Ribble Valley Borough Council  
By email

Your ref 3/2021/0275  
Our ref DC/23/1403 v9  
Date 09-JAN-24

**Location: Land behind The Dog Inn, Market Place, Longridge PR3 3RR**  
**Proposal: Proposed erection of 9 new dwellings and associated works**

**DRAINAGE – \*REQUEST FOR FURTHER INFORMATION\***

Longditudinal Section along runoff path
1 : 50

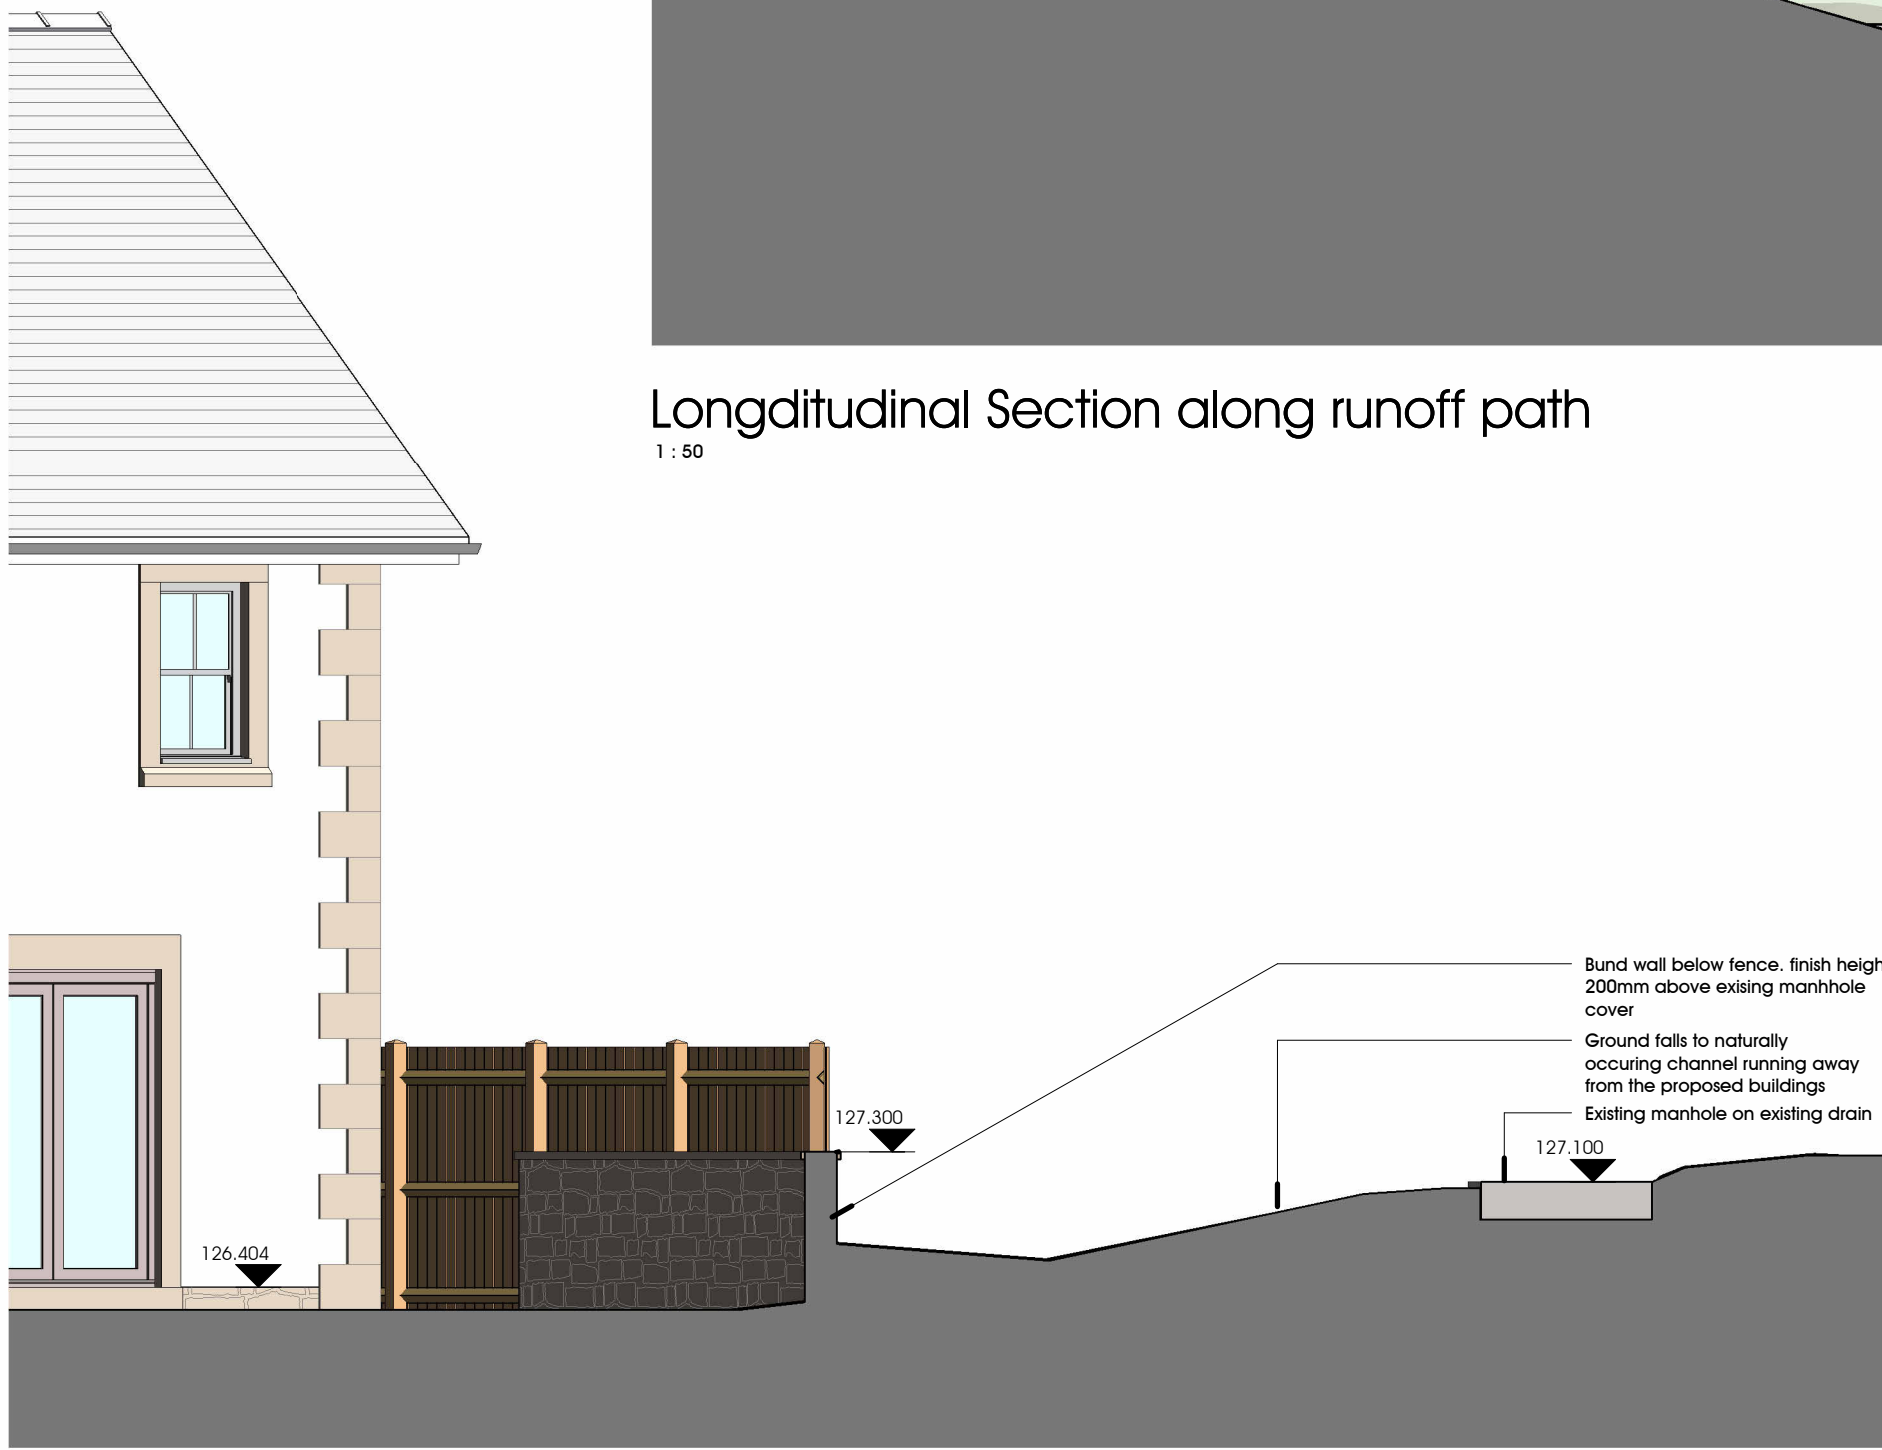
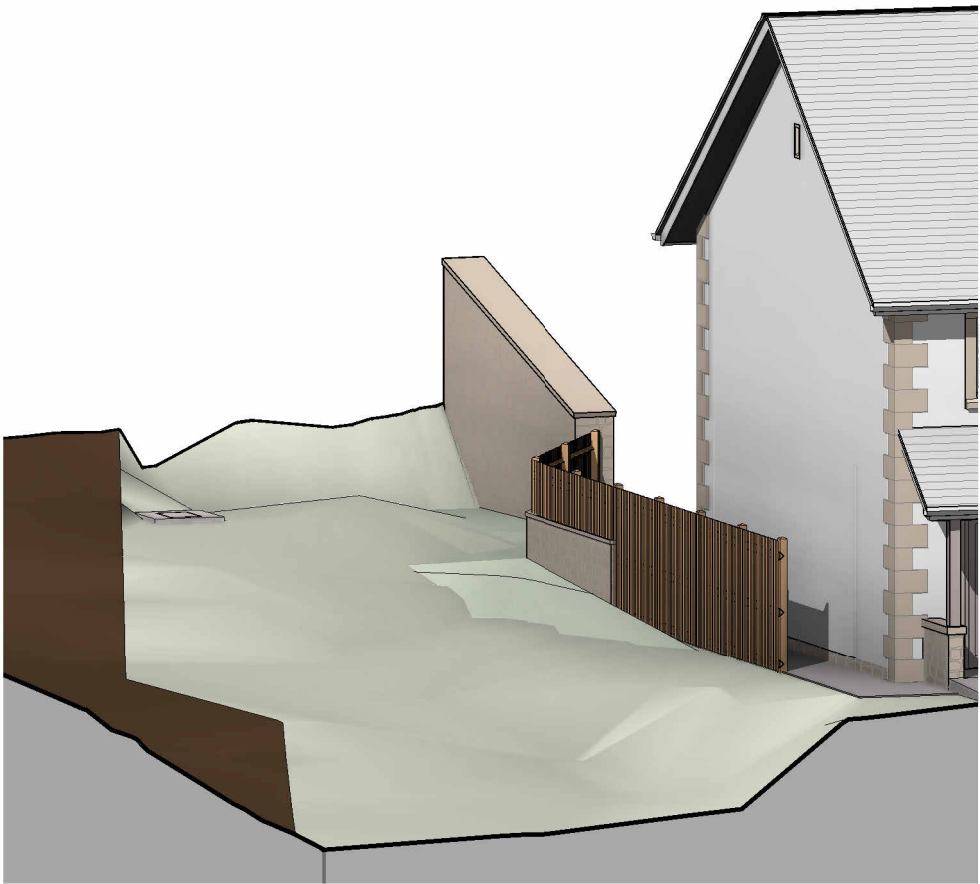
Further to our previous responses to this planning application we still have concerns regarding the potential overland flow from sewer surcharge and the potential flood risk to the proposed properties. In order to ensure the properties are not at risk of flooding from exceedance flows we request that the finished flood levels are raised above the cover levels for the existing and proposed drainage systems.

Proposed Site Plan
1 : 200
0 1 5 10m

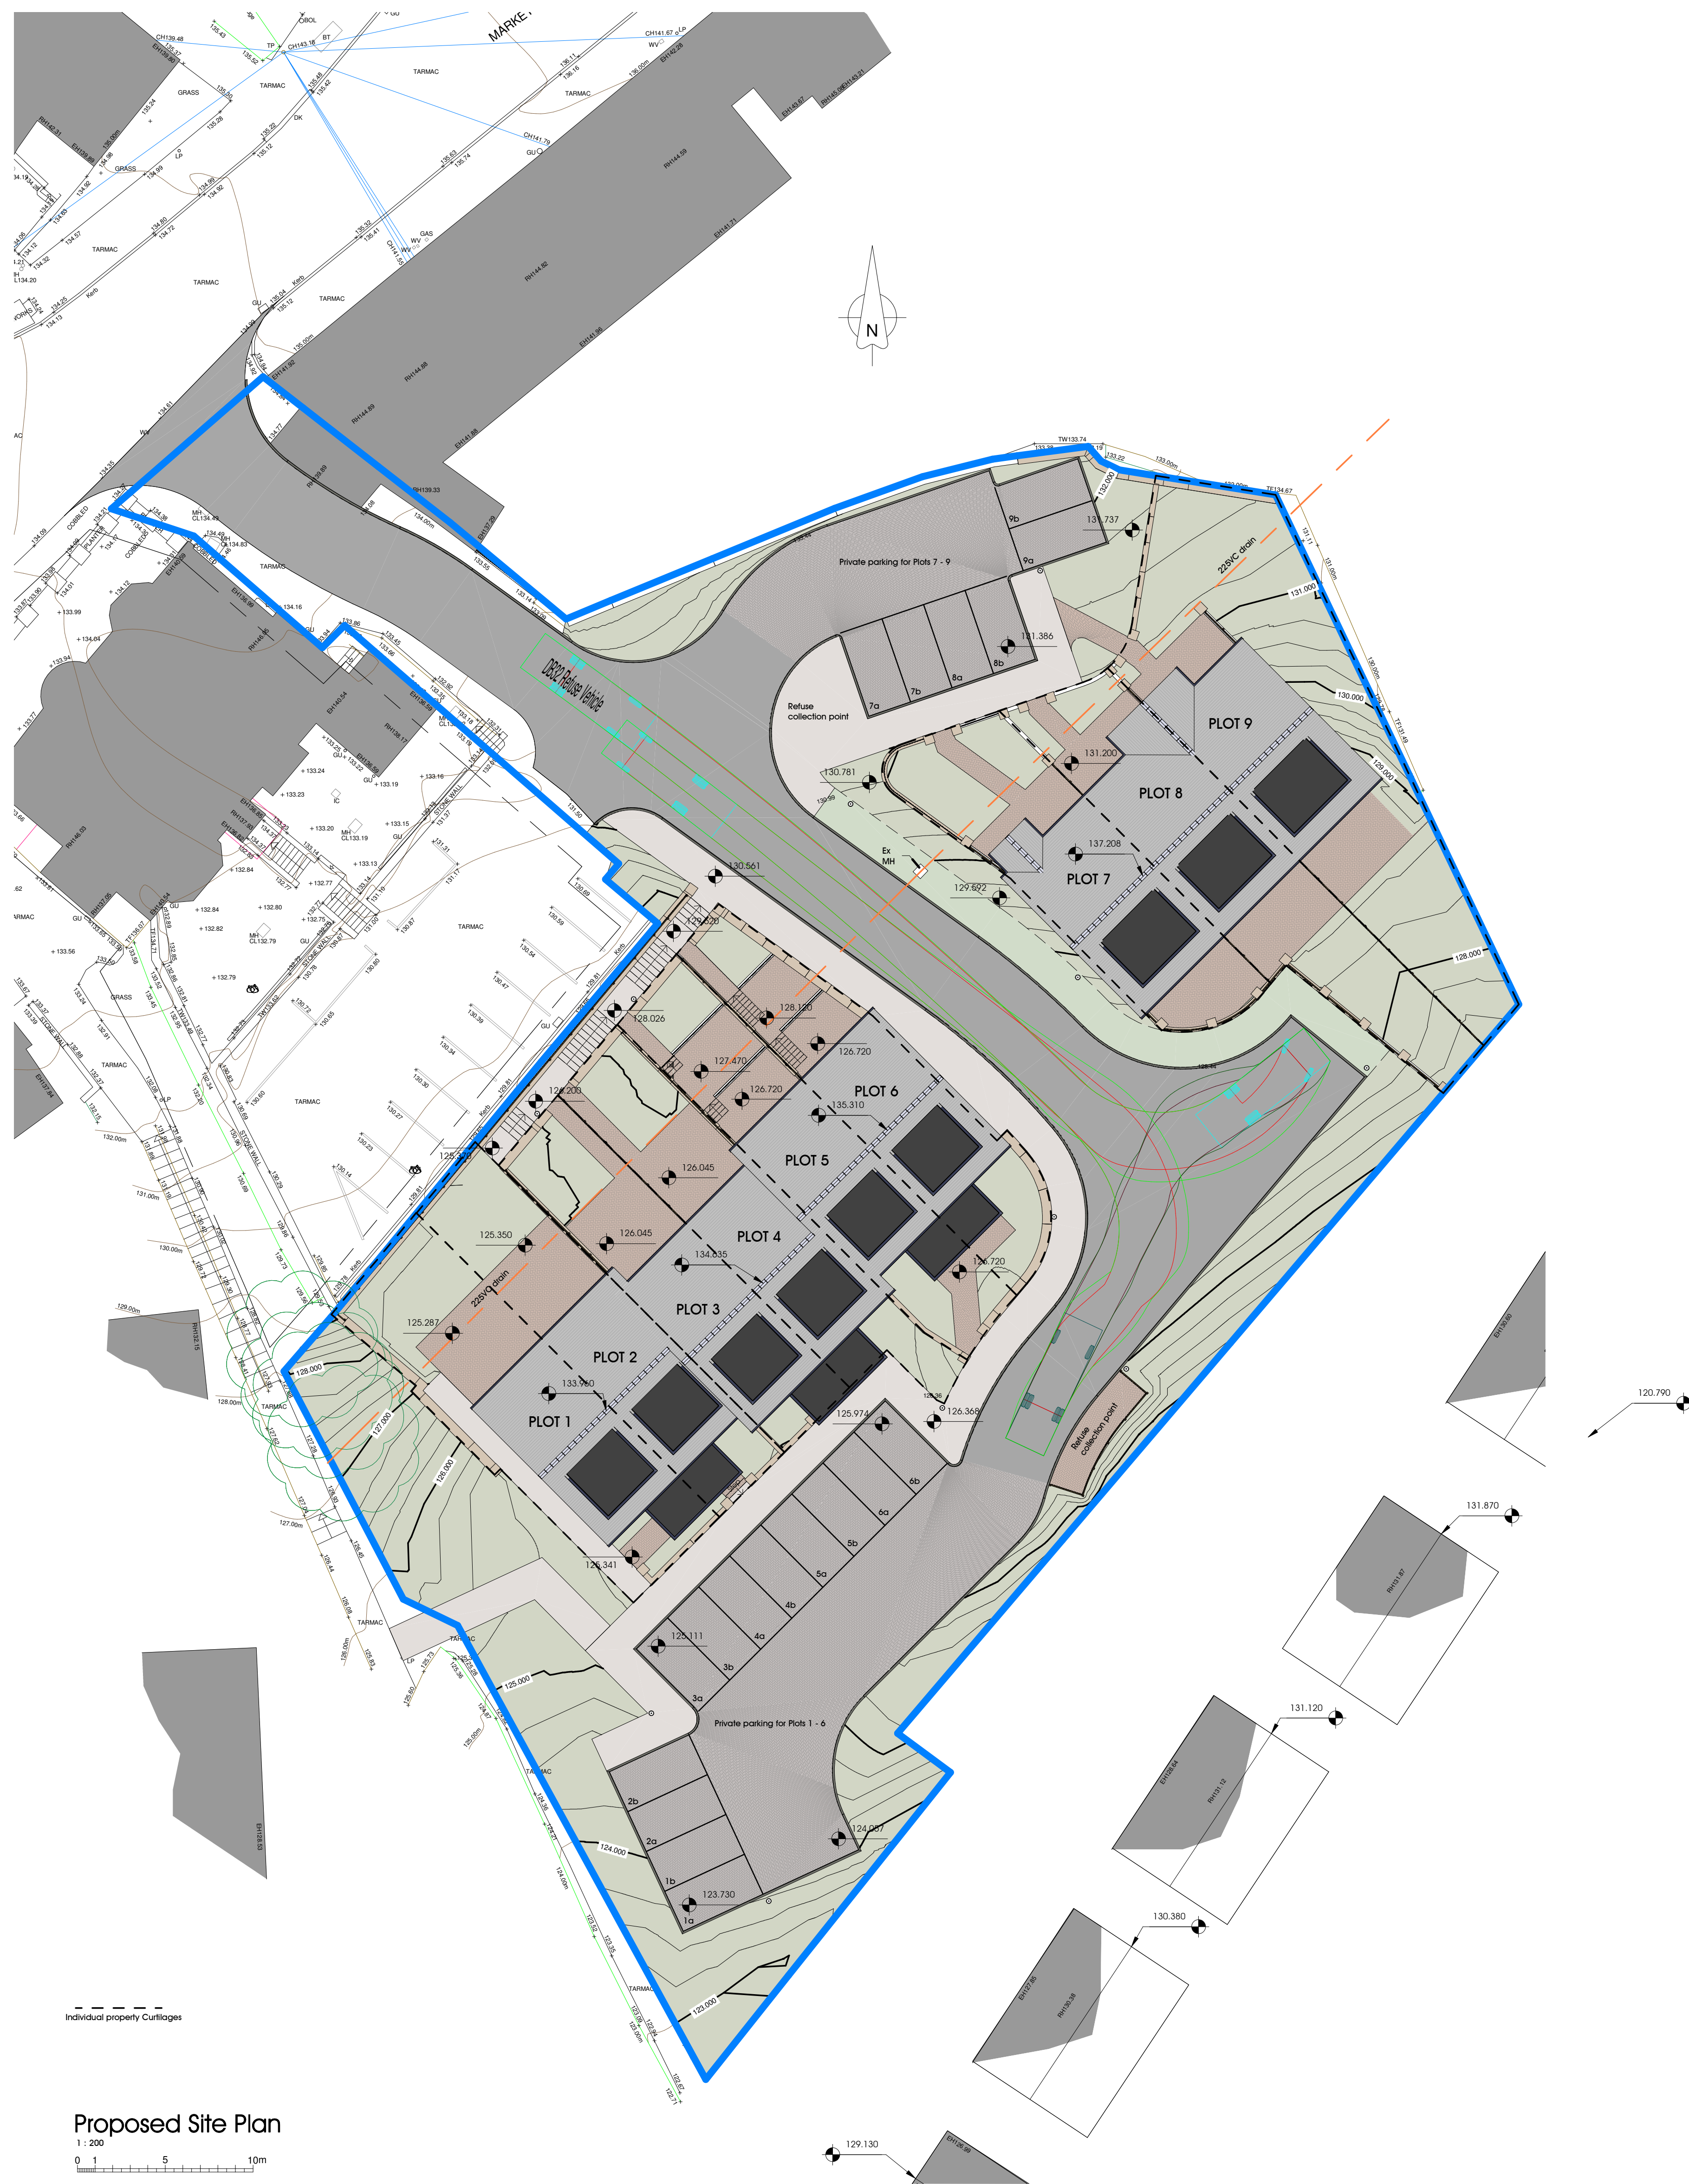
**A public sewer crosses the site and we may not permit building over it.** We require an access strip for maintenance or replacement. The minimum distances that might be acceptable to United Utilities are detailed within Part H of the Building Regulations however, **we recommend the applicant determines the precise location, size, depth and condition of the pipeline as this is likely to influence the required stand-off distance from any structure and could impact upon the proposed site layout.** We would like to draw the applicant's attention to further information contained in the Appendix to this letter, Section 2.0 'United Utilities' Property, Assets and Infrastructure'.
